Re: 24-FRM-018
Framing concern
Lot 8 Cotton Farms

At your request, the provided plans were reviewed for the above referenced single family residence under construction to address the connection of the end I-joists at each side of the cantilevers above the front porch to the LVL rim at the front side of the cantilevers.

SECOND FLOOR STRUCTURAL PLAN

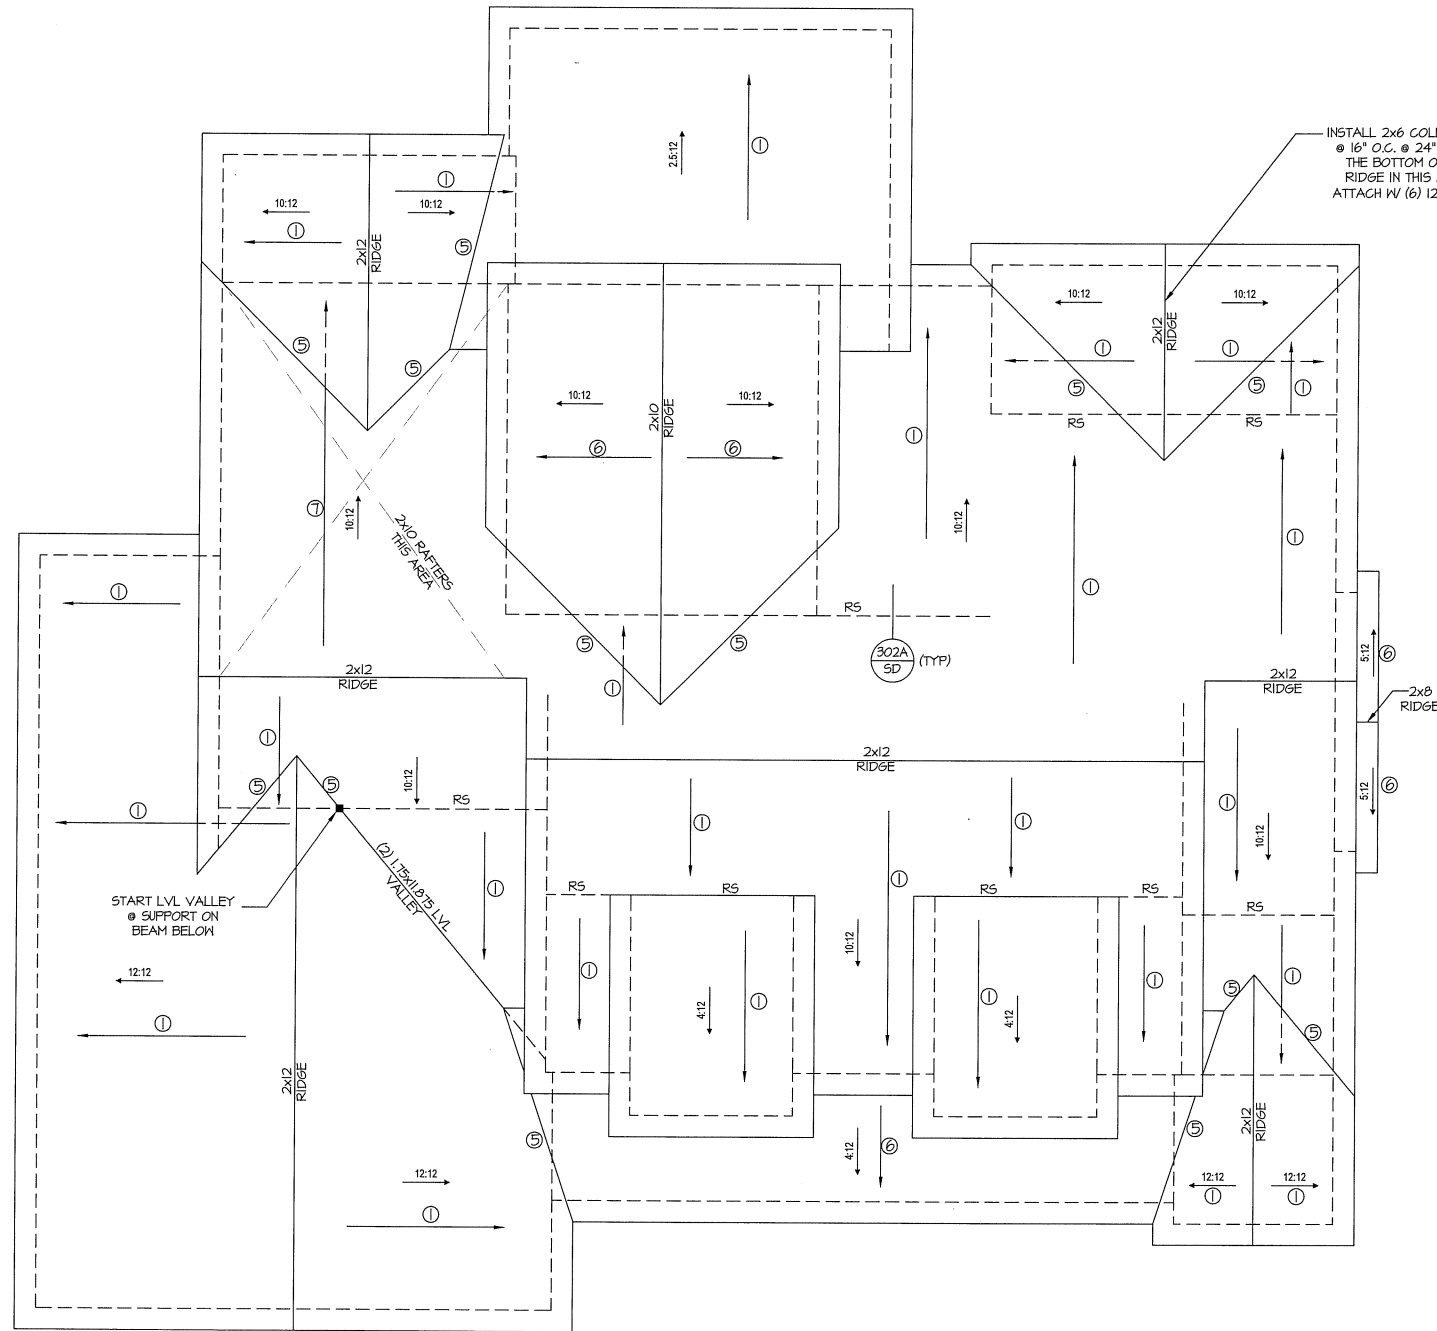
You indicated the (4) noted I-joists had no connection to the LVL rim and face-mount hangers could not be installed due to the outer flange lacking a nailing service.

Each of the (4) noted I-joists are to be fastened to the LVL rim with (2) Simpson Strong-Tie LS70 skewable angles stacked horizontally. The web of each I-joist is to be packed-out per the manufacturer's specifications prior to installing the angles. This prescribed framing configuration will provide the required support for all imposed loads.
